## TOWN AND COUNTRY PLANNING ACT 1990 FULL

**Reference:** H09-0210-25 **Date of Decision:** 1st May 2025  
**Applicant:** Mr N Marshall  
C/O Lincs Design Consultancy Ltd.  
12 Vickers Lane  
Louth  
Lincs  
LN11 9PJ  
**Location:** Bank House 1 Albert Street Holbeach Spalding  
**Description:** Conversion of 2 existing flats to create 4 flats

### **South Holland District Council hereby give notice that this application has been REFUSED for the above proposal for the following reason(s):**

PROPOSED FLOOR PLANS
scale 1:100

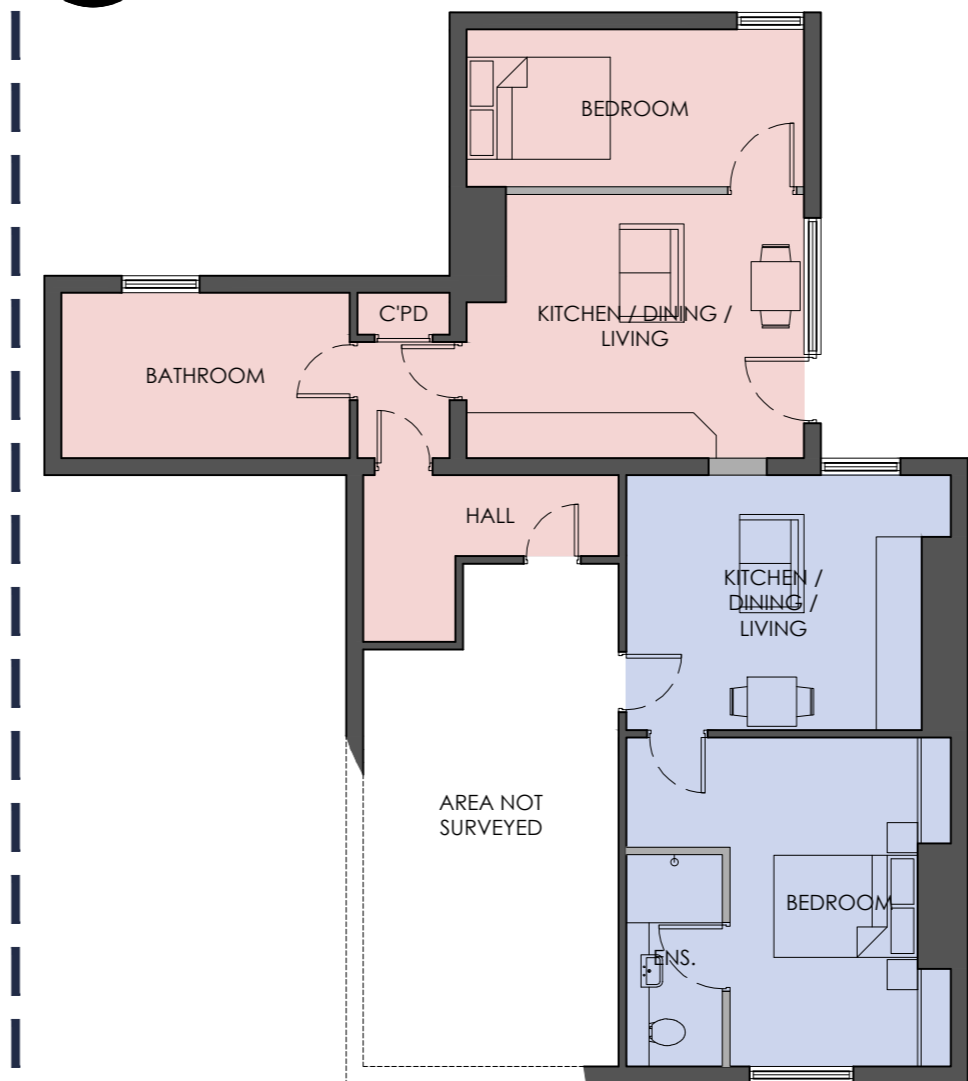
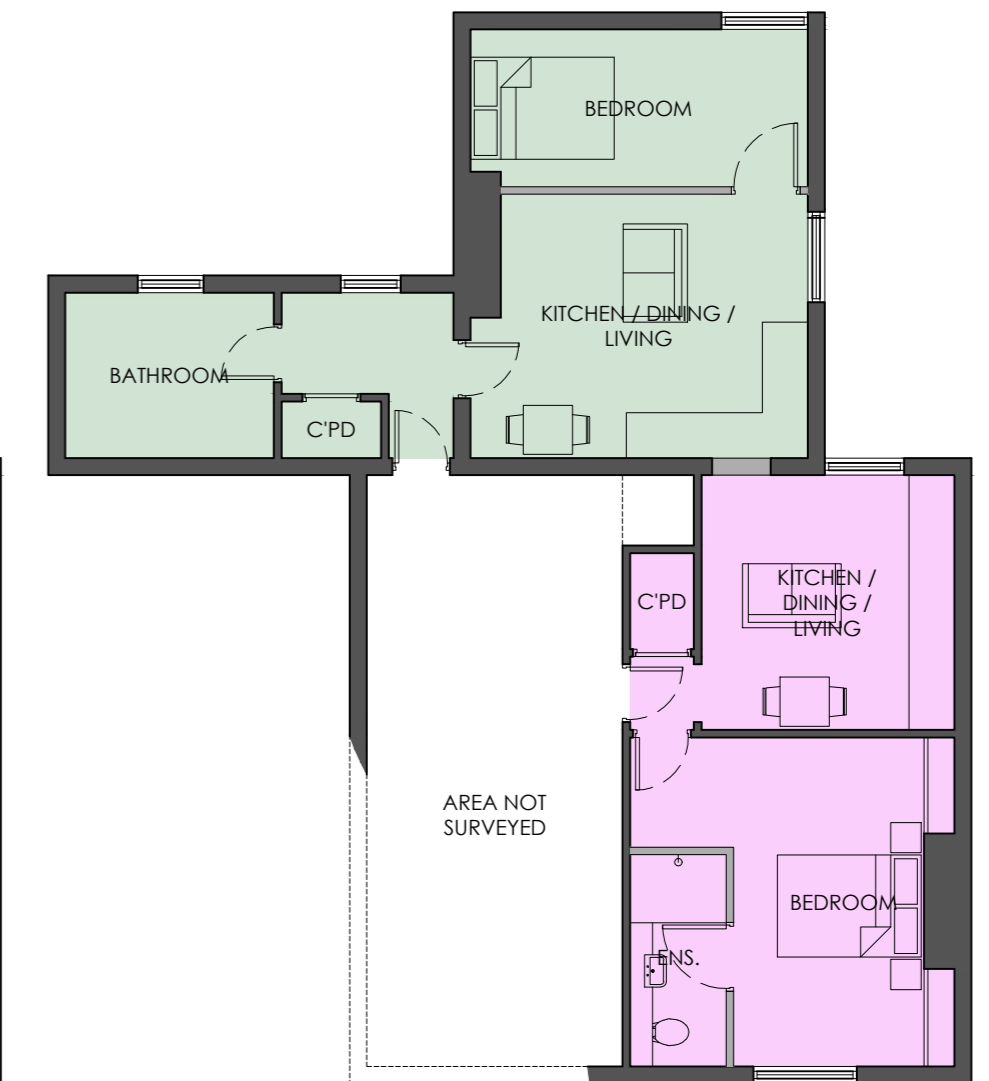
- 1 The accommodation hereby proposed is considered to provide an inadequate standard of residential amenity for its occupants. Two of the four proposed dwellings would fail to conform to the Nationally Described Space Standards, with no communal space, such as gardens or communal living areas, available to compensate for this.

Accordingly, the proposal is considered to conflict with the requirements of Policies 2, 3 and 21 of the South East Lincolnshire Local Plan, 2019, which explicitly require conformity to the Space Standards, as well as Section 12 of the National Planning Policy Framework, December 2024.
